**Re: PA23-012 – English Crossing Townhomes – Technical Review 3**

SUBJECT: PA 23-012 – English Crossing

RE: English Crossing, File# PA23-012  
247 New Townhomes  
17406 19<sup>th</sup> Ave NE & Parcel # 31051900401200

SHEET
 P1 of P3
 24x36
 PA 23-12

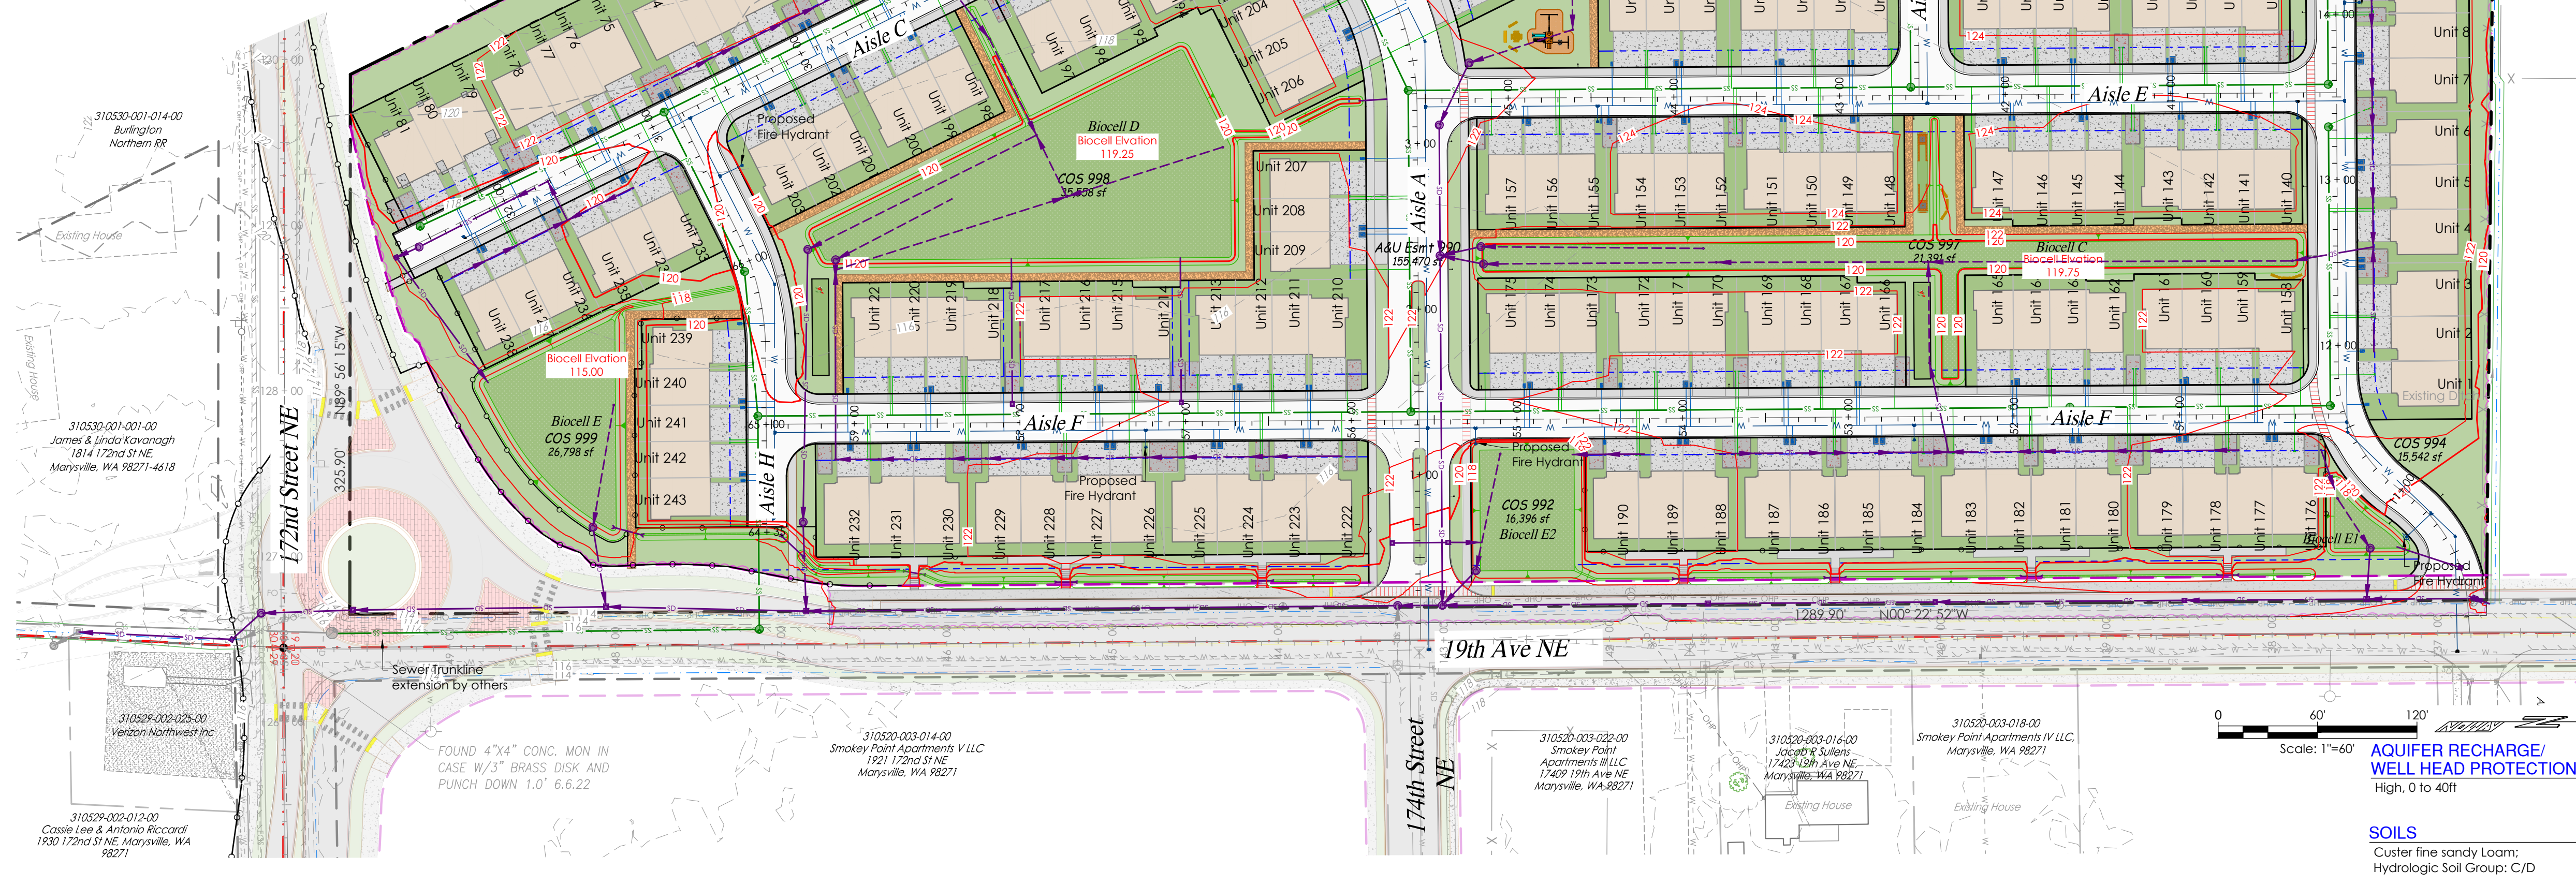
- a. It appears that a 15 foot dedication is necessary along 19<sup>th</sup> Ave to provide a 35 foot half width of right-of-way. Which is consistent with the typical dedication shown on the required road section shown on SP 3-201-004. As the adjacent project should have dedicated additional right-of-way and moved the centerline of the road to the east, as stated above the City is agreeable to a modified section and deleting the planter strip.

- b. As shown on the supplied drawing additional area is necessary for the roundabout and widening on 172<sup>nd</sup>. At this time I cannot be specific on the amount of area that will be required as the design is not yet complete. The project will need to dedicate the area necessary to encompass all the required improvements.

4. **Access:**
  - a. The northern most access apron may need to be realigned, it does not appear to meet the angle of intersection.
5. **Drainage:** All projects in the city of Marysville must comply with requirements stipulated under MMC 14.15.040 and 14.15.050.
